Application for a Non-Material Amendment Following a Grant of Planning Permission

Development: Changes to certain materials/details , namely:-

Location: Mayflower Way Angmering BN16 4AY

Thank you for your application submitted via the internet on 1st June 2021. It has been downloaded and will be checked for validity by the Technical Support Unit. It has been allocated the reference number **A/111/21/NMA.**

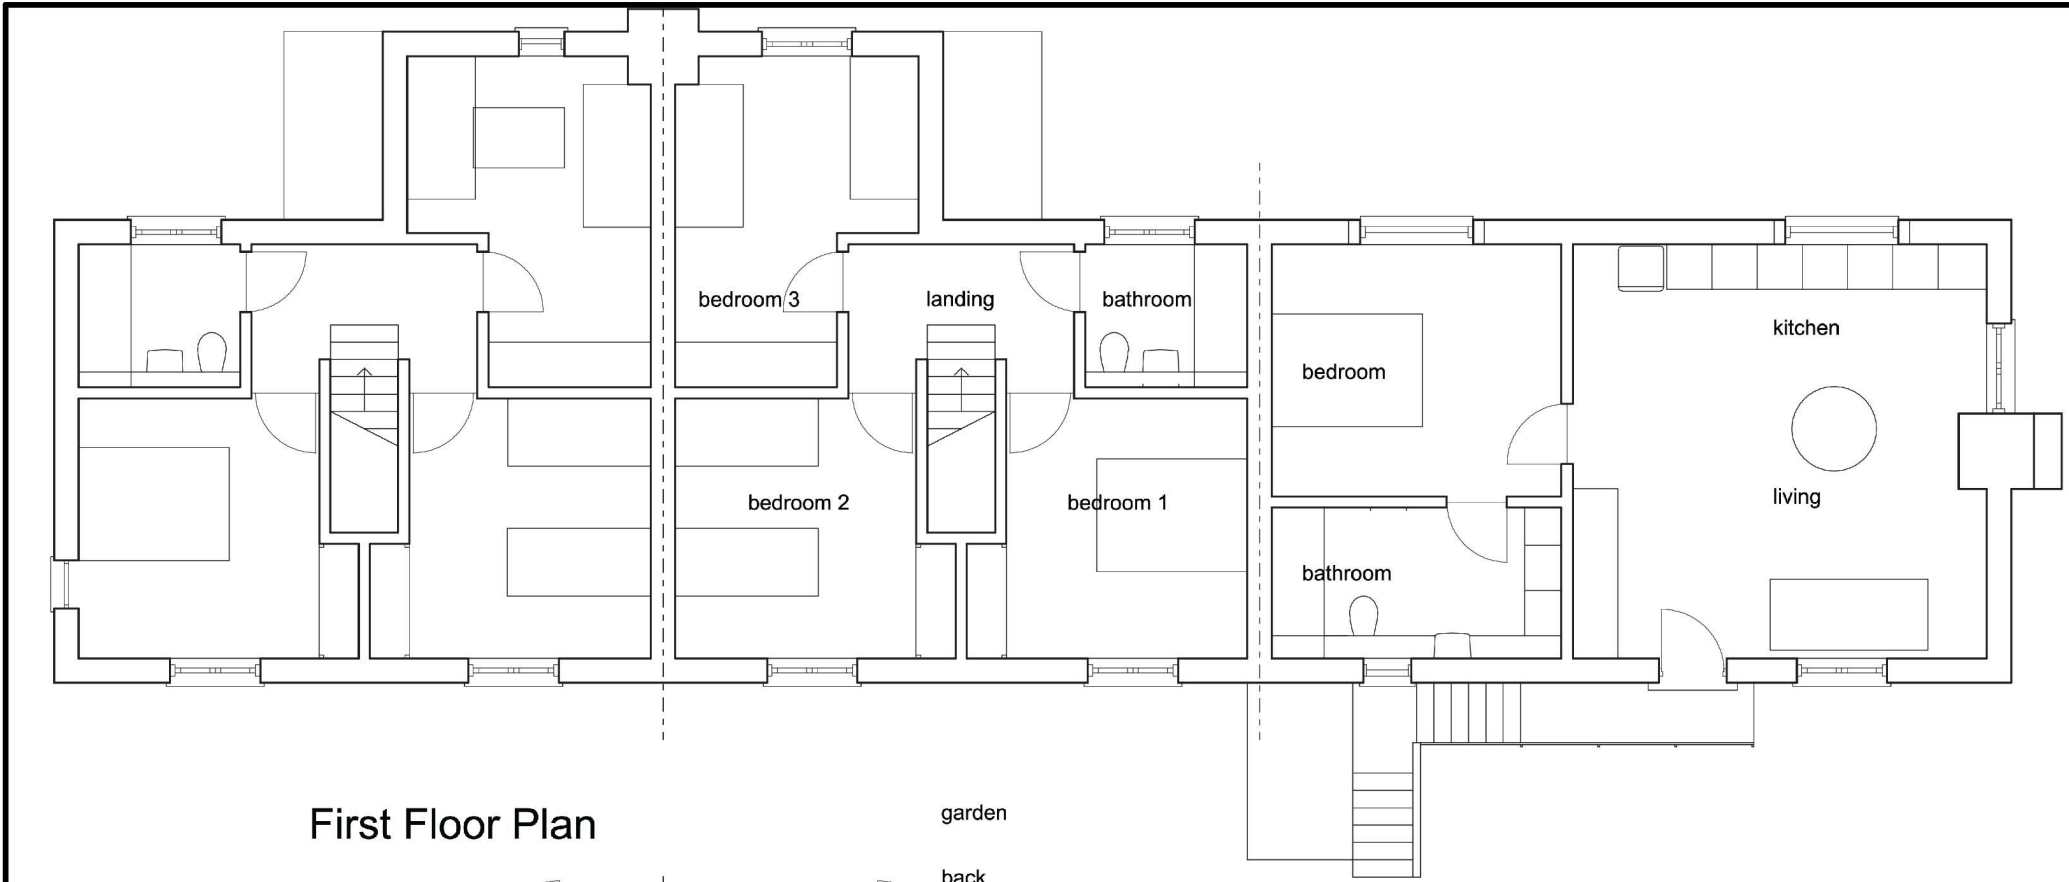
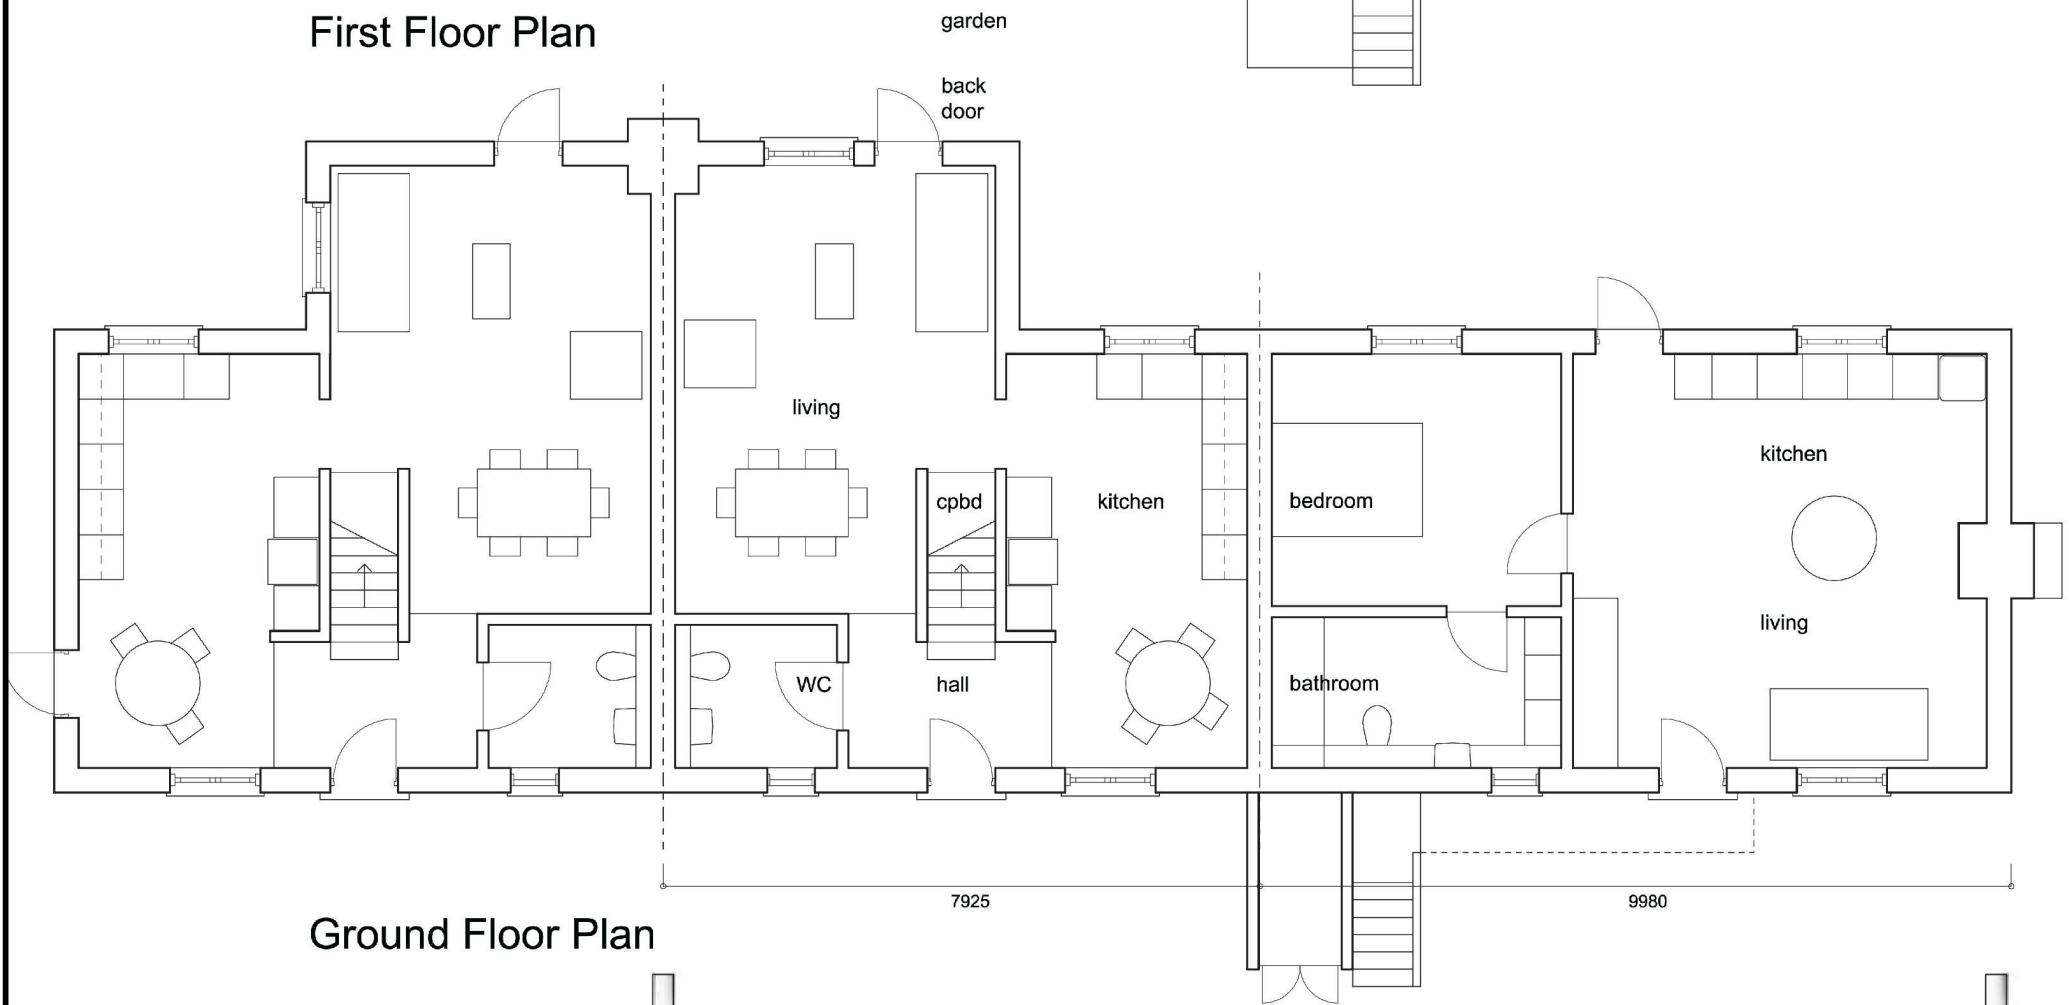
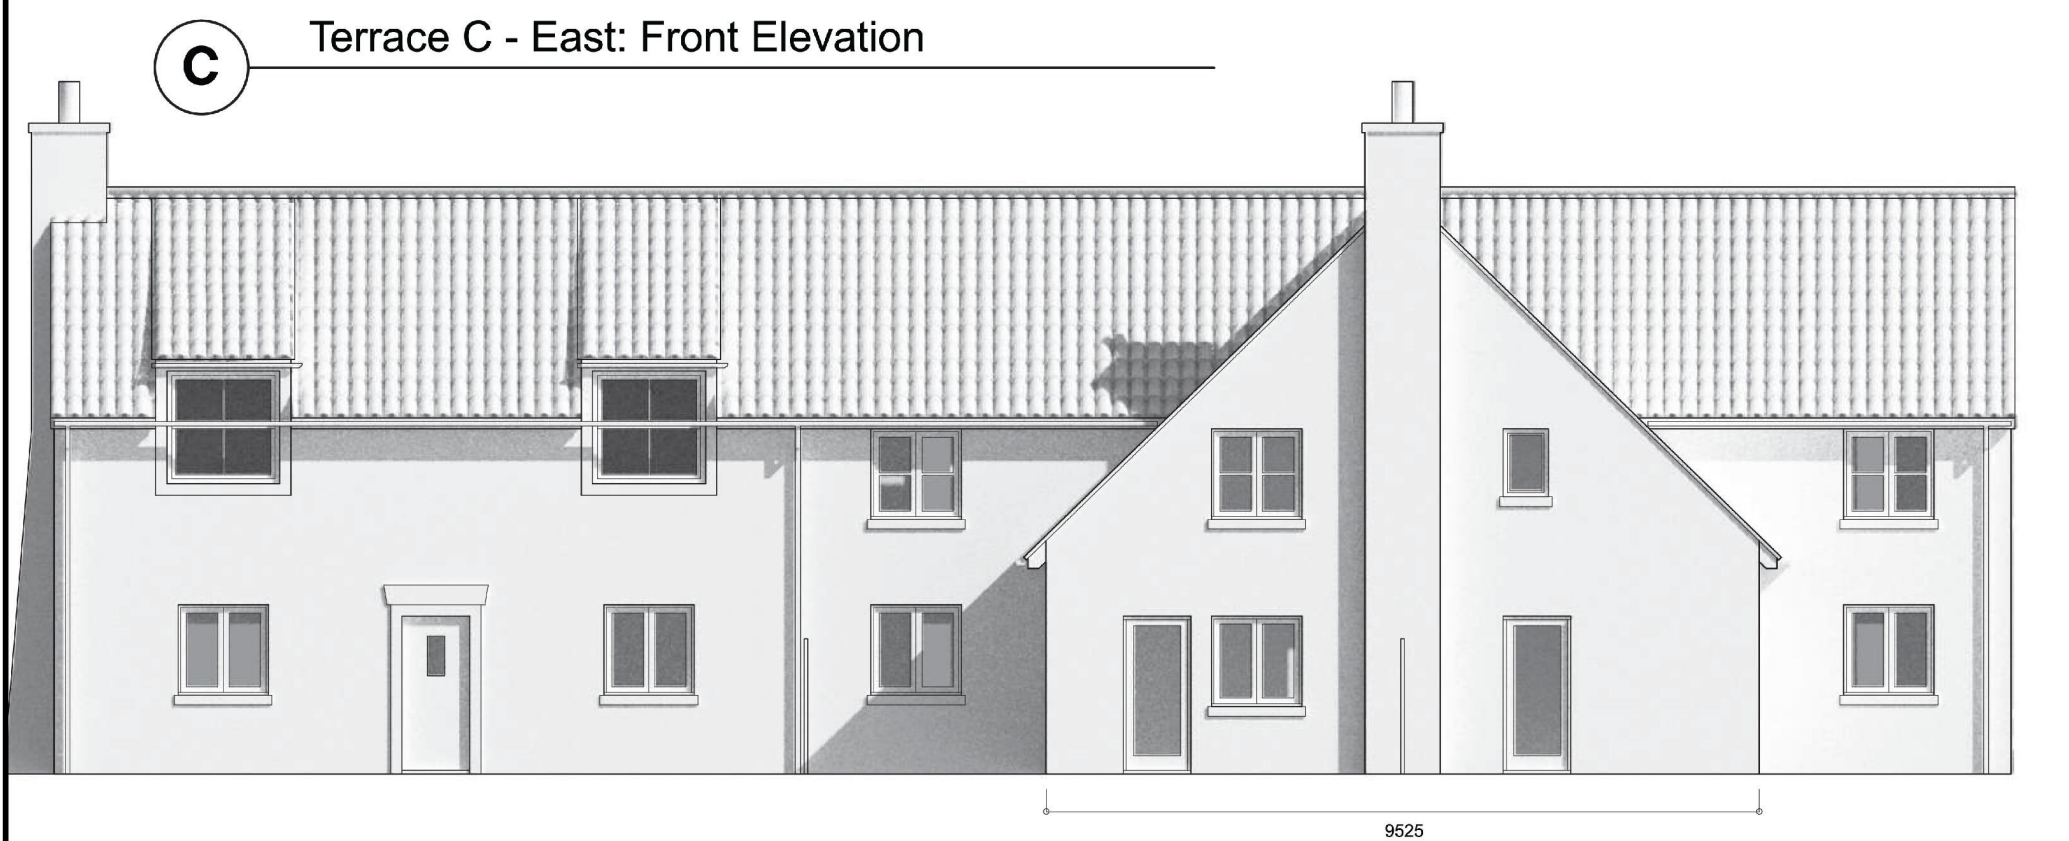
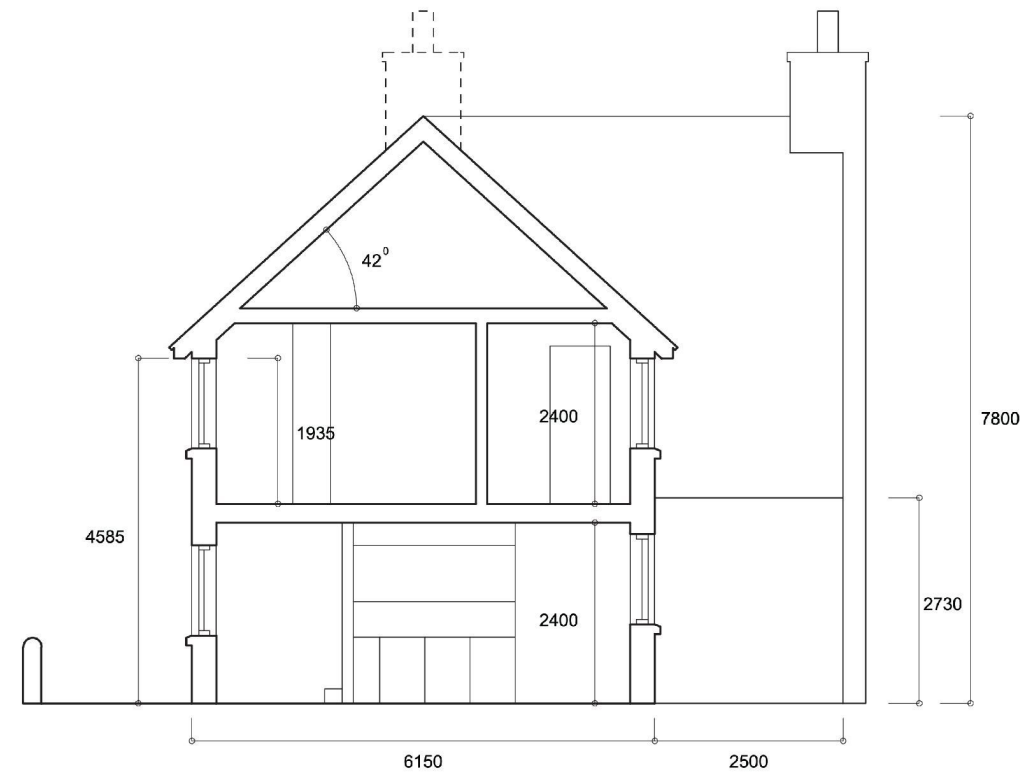
- 1 There is no gas supply to this site and wood burners are environmentally damaging. Given these facts then the chimneys/flues will not be working items. It is proposed to remove the galvanised steel flues however all chimneys will remain but non-functional, with traditional masonry flues (pots). Reason: Environmental considerations

- 2 Roof tiles shown as clay pantiles will be changed to concrete pantiles while providing the same overall appearance. Reason: Development costs
- 3 Roof tiles to be artificial Slate providing the same overall appearance. Reason: This is clarification of what was only stated at planning as slate. Development costs would direct us to artificial.

- 4 Rainwater goods to be black PVCu with cast Iron effect. Reason: Development cost and on-going burden of cyclical maintenance.
- 5 Windows to be PVCu White providing the same overall appearance Reason: Development cost and on-going burden of cyclical maintenance.

- 6 Front doors to be GRP composite PAS24 while providing the same overall appearance. Reason: Development cost and on-going burden of cyclical maintenance.

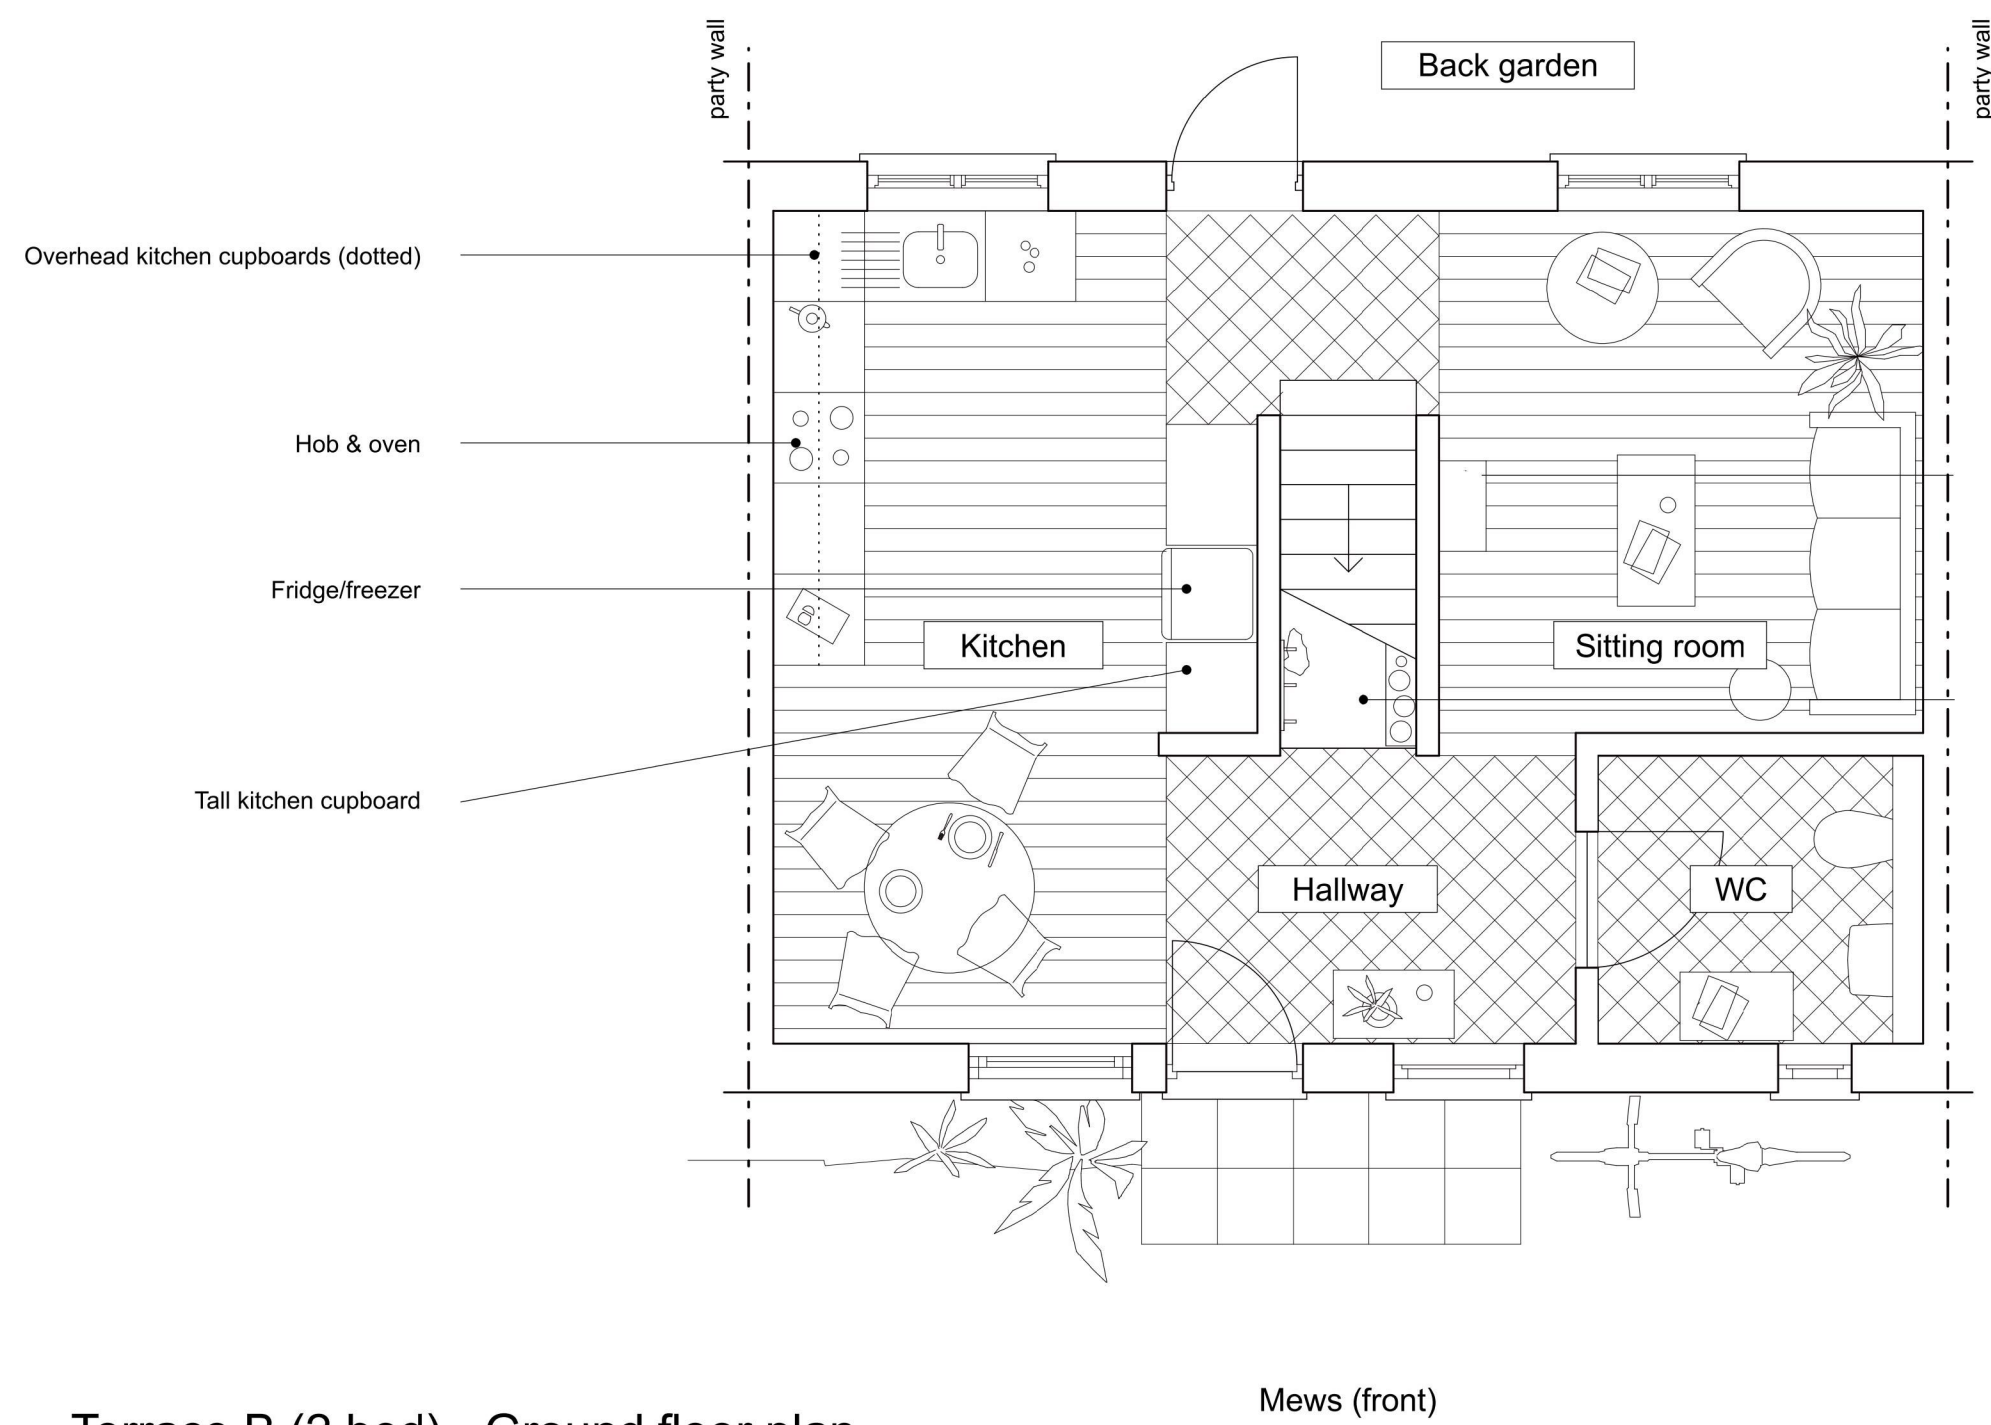
- 7 - Lintol treatment amended where noted on drawings: RSJ detail changed in favour of homogenous brickwork, & window lintol treatment amended as noted
